Planning reference: 3/2025/0873

Location: Land at Springwood Drive, Whalley, BB7 9XL

Proposal: Construction of six detached dwellings with associated parking and landscaping at land off Springwood Drive

We refer to the letter from the Environment Agency dated 6th March 2026 in which the Environment Agency maintained their objection to the planning application, the reasons being given are below with our responses alongside.

PROPOSED SITE SECTIONS & STREETSCENE

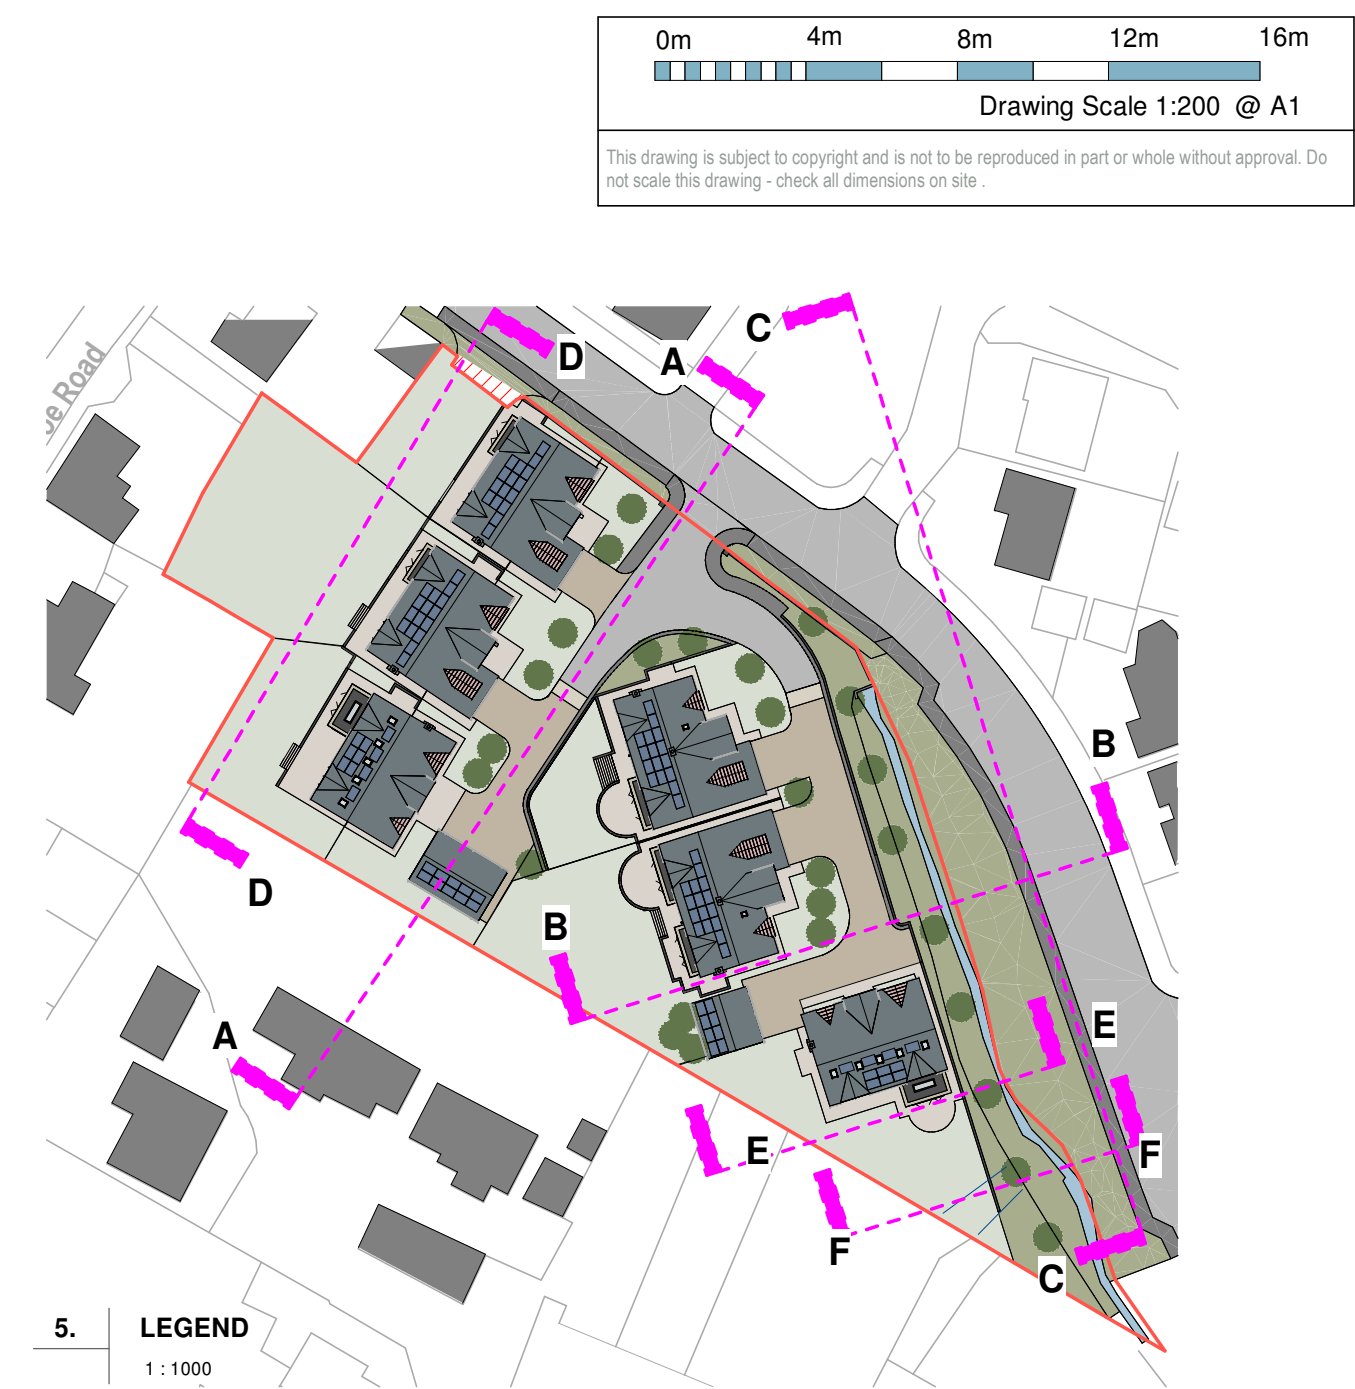
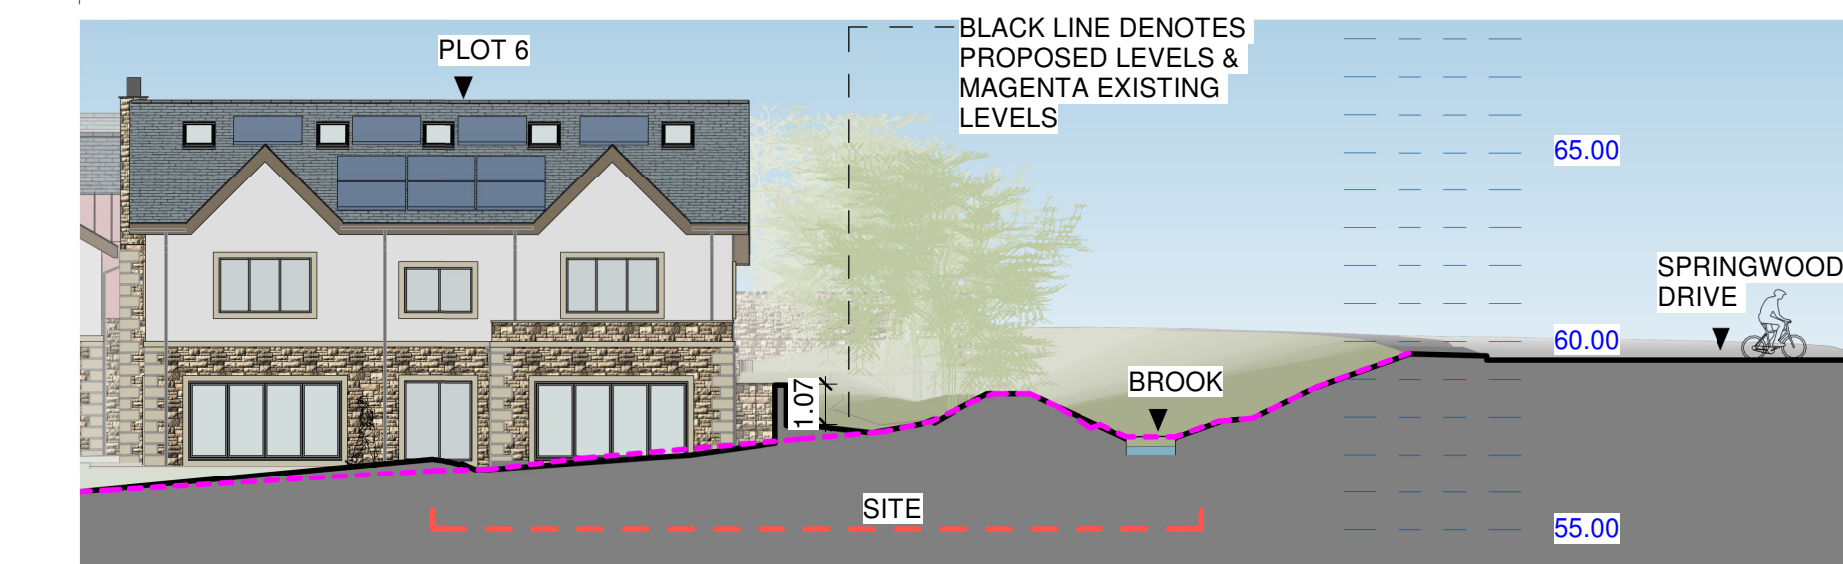
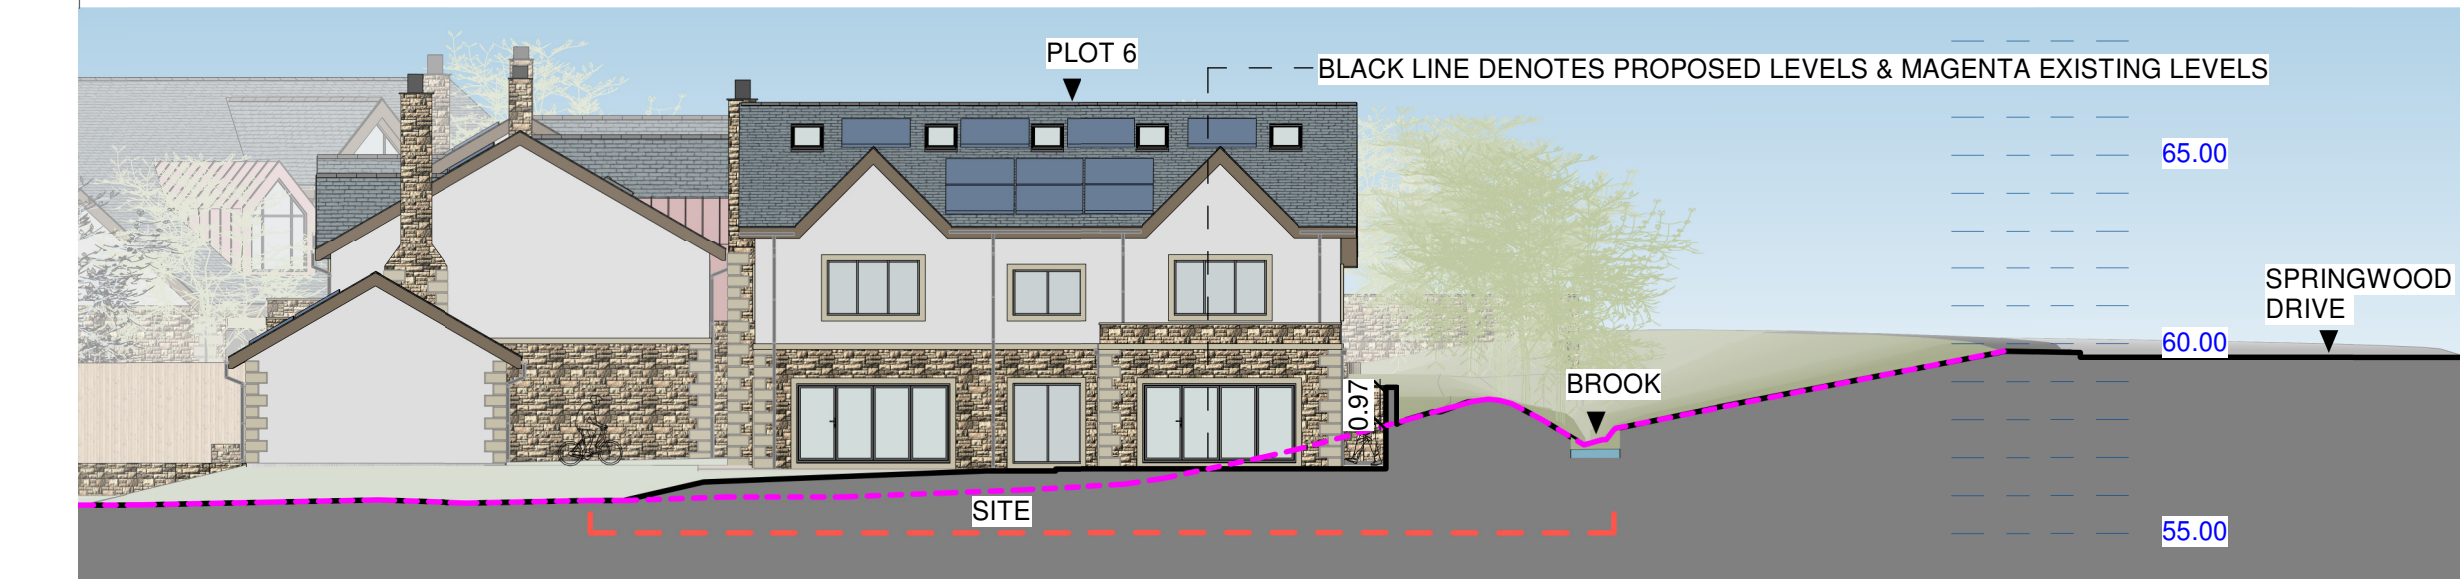
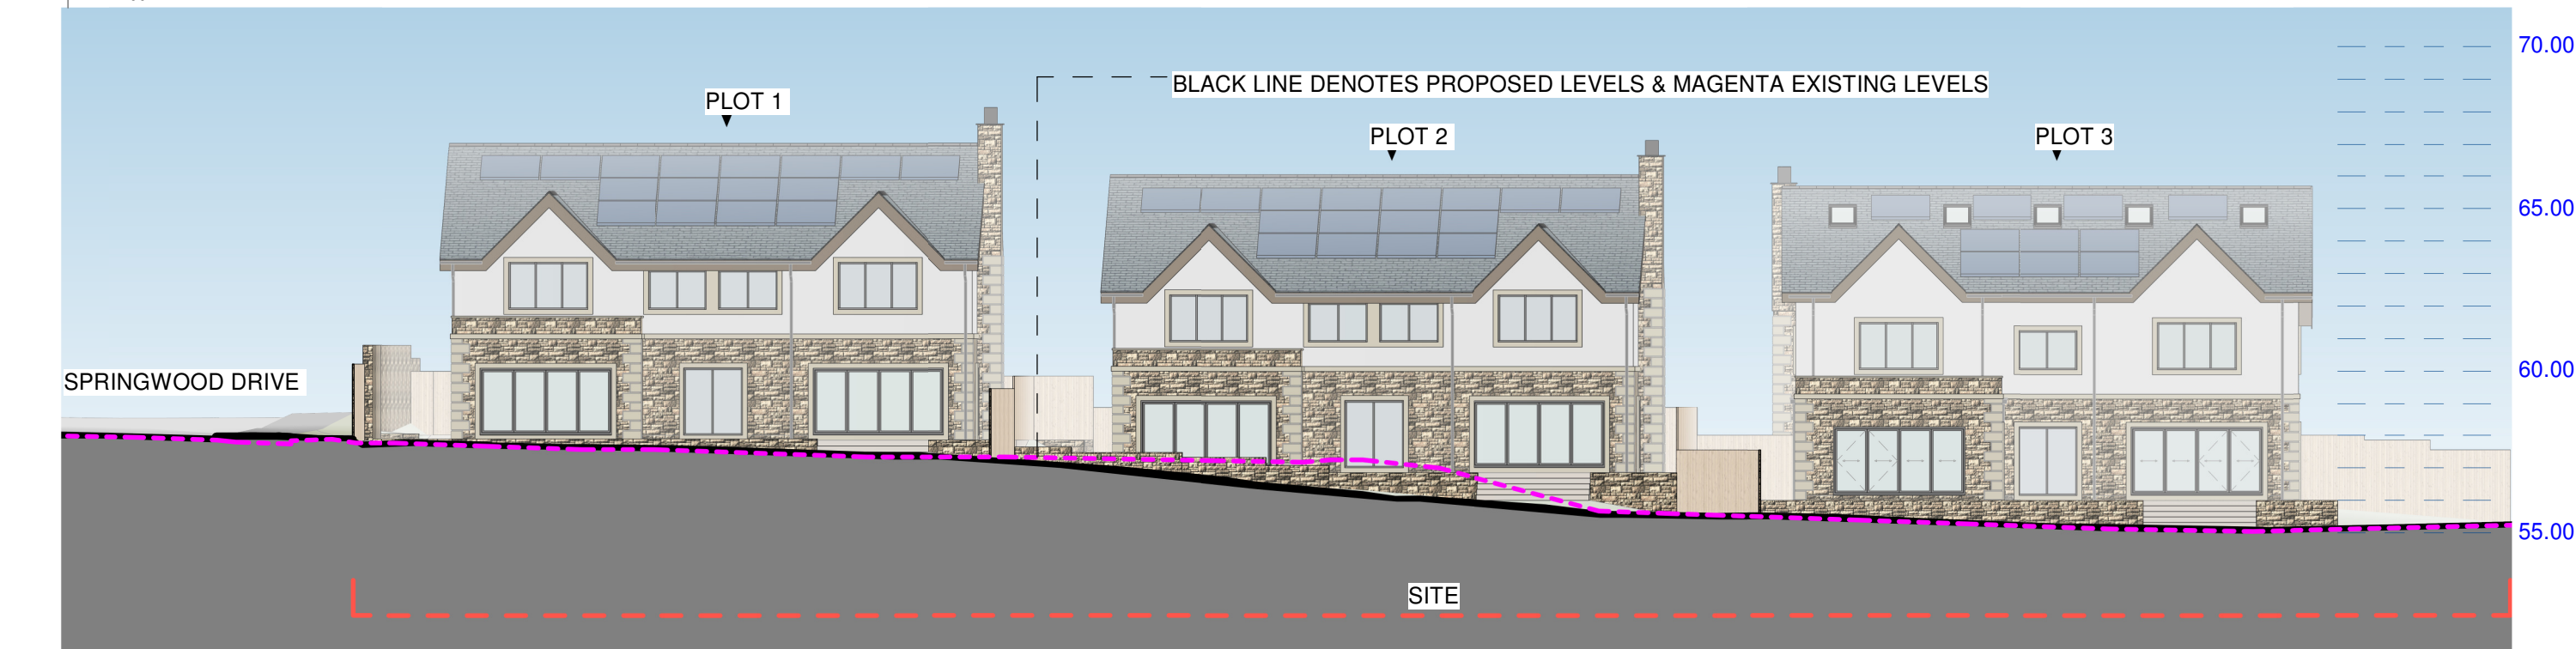
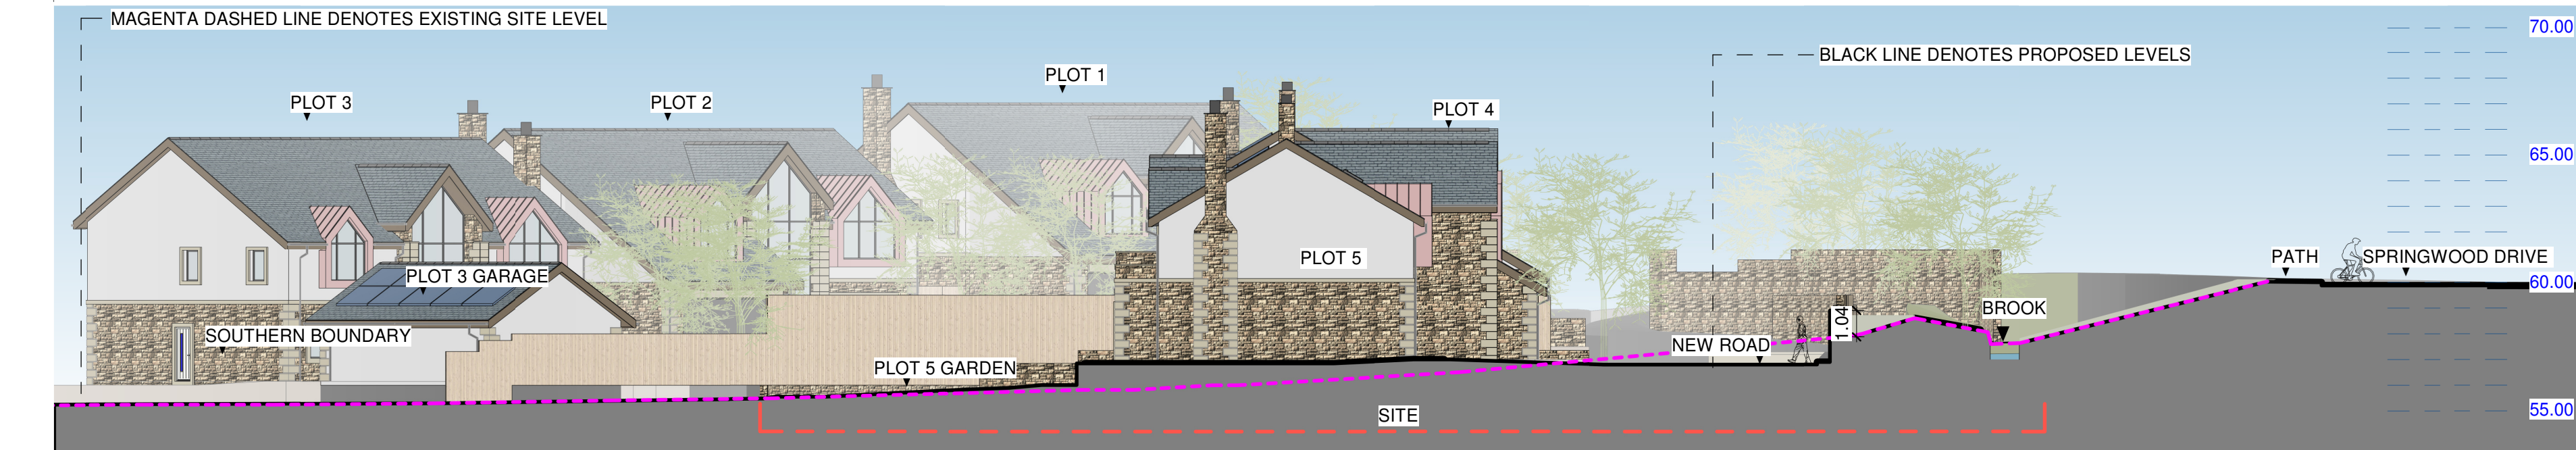
With regards to potential future floodplain encroachment north-west of the site (which is informed by the New National Model) – the FRA states “The route of this overland flow will not be obstructed by the proposed development, ground levels within this area of the site remaining existing”. The applicant should provide a site plan (with appropriate topographic information) overlayed with Flood Zones (namely Flood Zone 2 which is being used as a 'design flood proxy' as demonstration.

As it has been demonstrated that the 0.1% AEP flood level will remain within the Wiswell Brook channel and not overspill into the development site, the construction of a 300mm upstand within the site, parallel to the western bank of the Wiswell Brook, will not increase flood risk elsewhere.

As requested, further sectional drawings have been produced and are provided with this letter.
